August 20, 2025

SUBJECT: WDFW COMMENTS ON RU-25-00002 Dvorak

Thank you for the opportunity to review and comment on reasonable use application RU-25-00002 Dvorak, a proposal to construct a single-family residence on parcel 756735. The Washington Department of Fish and Wildlife (WDFW) is familiar with the property and met with Erin Minton, landowner representative, and Kittitas County on-site in August 2025 regarding the project's impact on Fish and Wildlife Habitat Conservation Areas (FWHCAs, CAO Chapter 17A.04), specifically riparian habitat.

SHEET TITLE: SITE PLAN

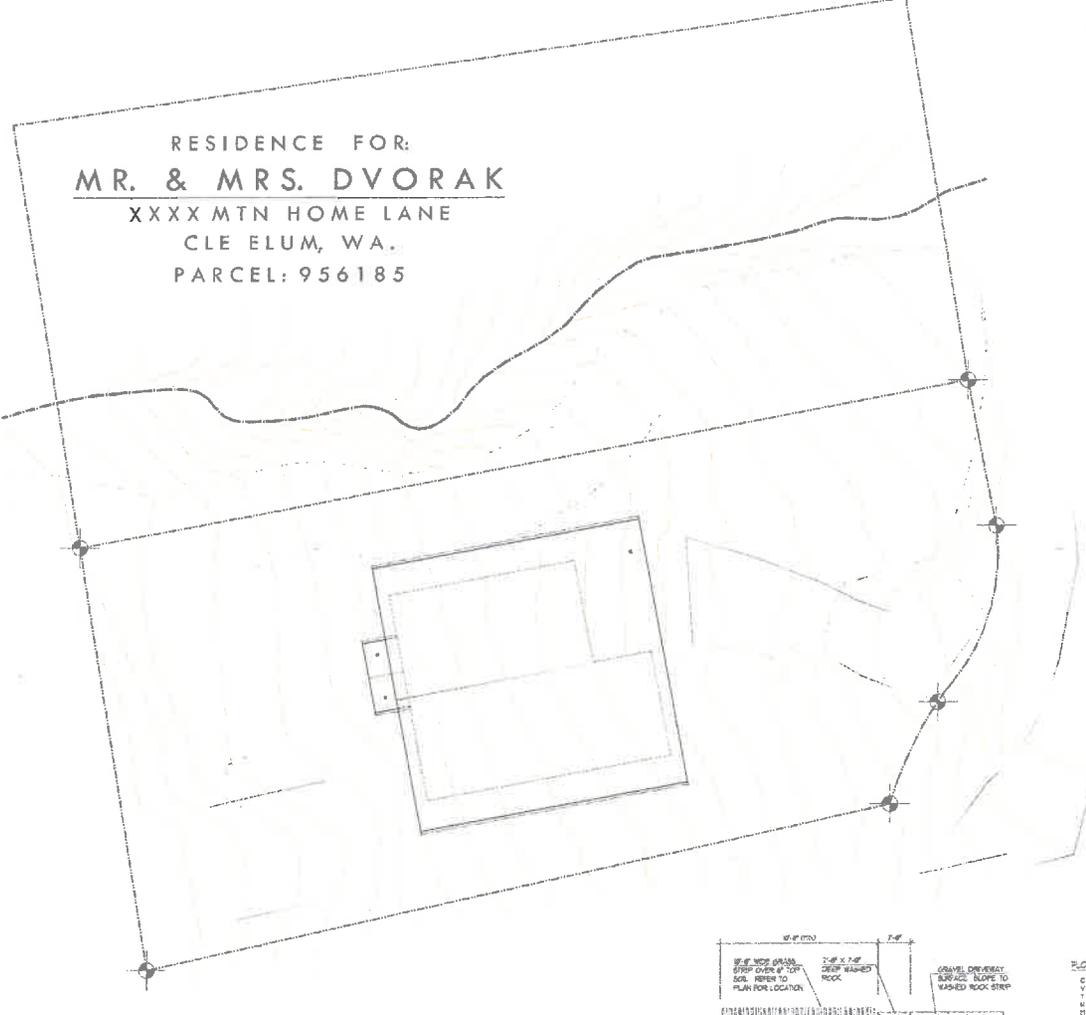
As observed during our site visit, there is a perennial stream flowing through the parcel, as referenced in the critical areas report. The proposed home site is located within the riparian management zone (RMZ, CAO 17A.04.030) of the stream. To ensure no net loss, we recommend avoiding and minimizing impacts to the RMZ as much as possible by siting the home and associated infrastructure as far away from the stream as possible. Where impacts cannot be avoided, mitigation will be needed to offset the impacts to the riparian buffer.

We appreciate the critical areas report, including proposed mitigation, included with the application materials. As discussed during our site visit, a planting plan should be developed following the metrics in the critical areas report – 7400sqft of planting, approximately 40 trees and 60 shrubs. Planting should occur on both sides of the stream. WDFW shared a list of native riparian plants for additional plant species consideration. The planting plan should include monitoring requirements to ensure survivability of the planted plants. We recommend at least three years of monitoring with an 80% survivability. If metrics fall below 80%, we recommend that similar plants be planted to replace those that did not survive. We request to review and provide concurrence to Kittitas County on the planting plan when finished.
